Rezoning Transportation Analysis

Petition Number: 2023-028

Date	Description
6-28-23	First Review (TM)
9-20-23	Second Review (ME)

SHEET NUMBER
RZ-1

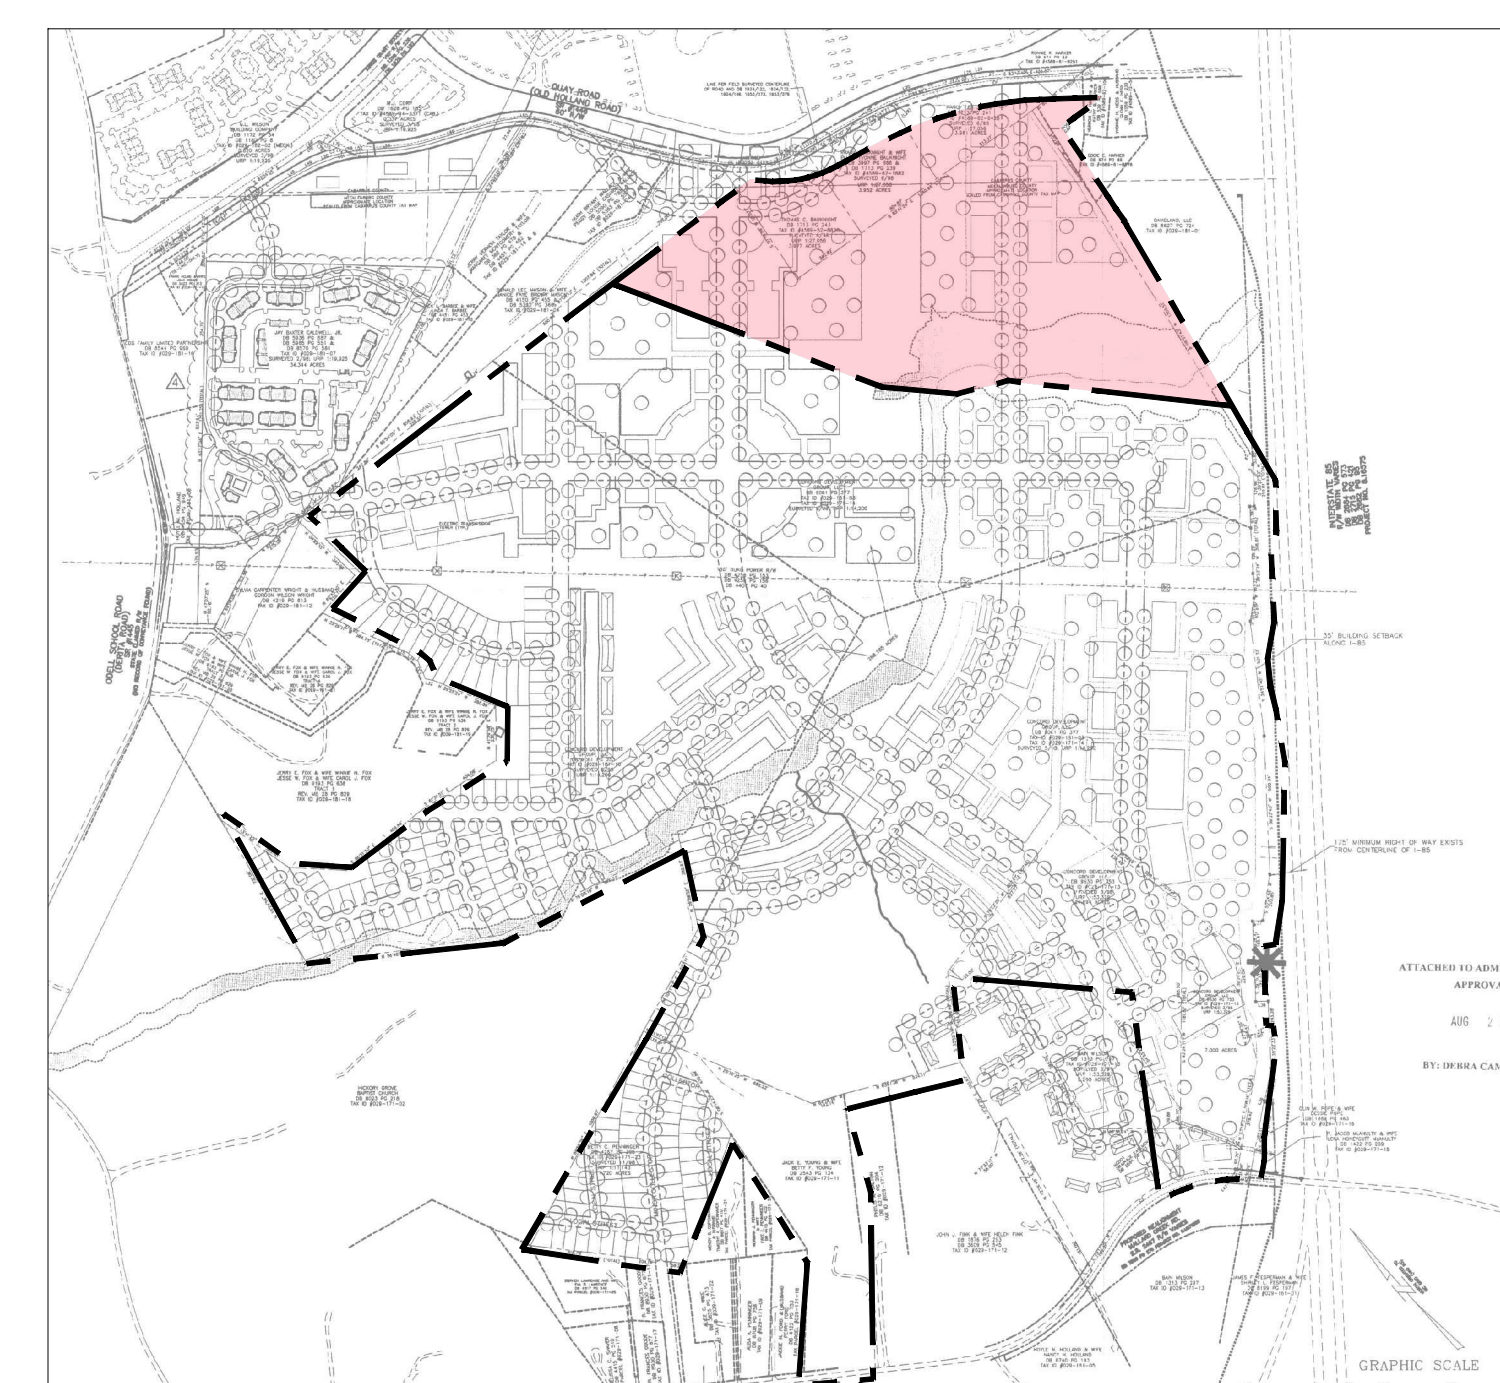
2. Revise site plan and conditional note(s) to commit to construct an 8-foot planting strip, and 8-foot sidewalk on newly N-S public Road per Chapter 20.

Clarifying comment 9.20.2023: Label and call out 8-foot planting strip and 8-foot sidewalk on roads on site plan.

Clarifying comment 9.20.2023: Based on latest conversation with Land Development Subdivision, please label Road B as publicly maintained within Mecklenburg county on site plan and alter conditional notes in sections 3, 4, and 5 to reflect changes.

5. Revise site plan and conditional notes(s) to commit to coordinating with CATS to provide a public connection to the nearest CATS bus stop to the North of the site.

Clarifying comment 9.20.2023: Edit conditional note to include coordination with CATS also.
